8<sup>th</sup> November 2011

Re: the residential development proposal at the Royal Ryde rehabilitation site.

I have had the opportunity to review the report done in 2005 by Colston Budd Hunt & Kafes regarding the traffic consequences of the above development.

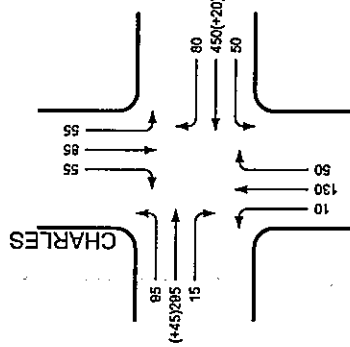
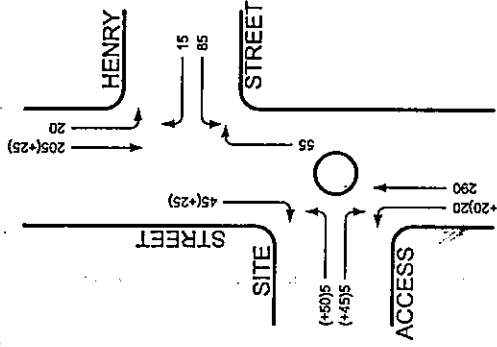
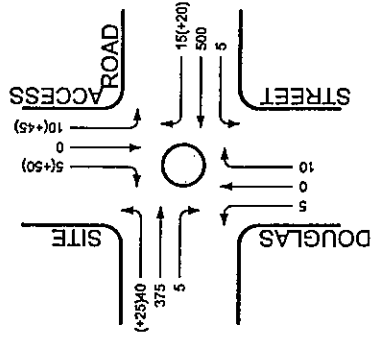
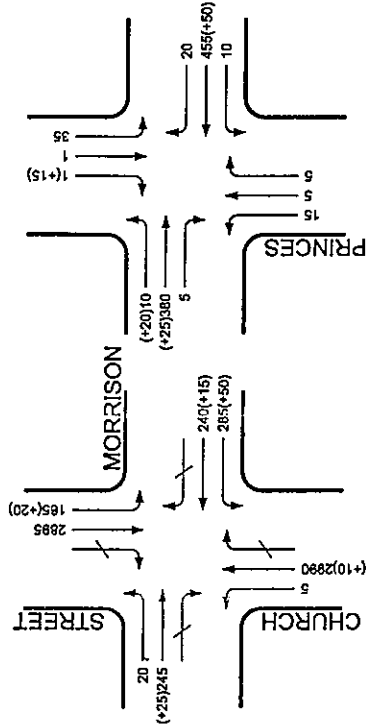
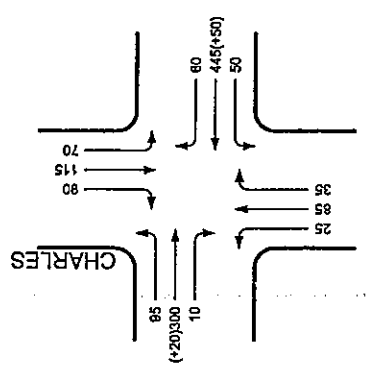
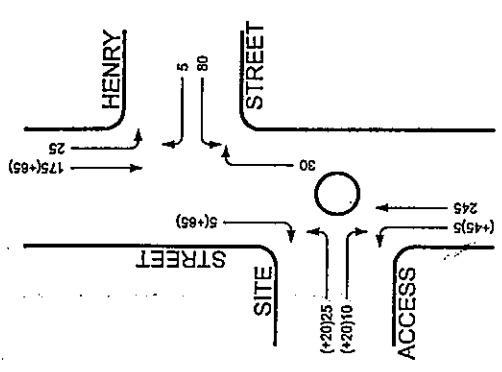
According to the report there would be 460 new vehicle movements per hour, 70% of which would be outbound. In 3.30 the report suggests traffic increase on Charles St would be 55-85 per hour. I would suggest that the increase would be in the order of 160 vehicles, thereby increasing traffic flow south of Victoria Rd to 730, well over the design capacity of this road. The close proximity of a primary school materially adds to the risk of a serious pedestrian accident.
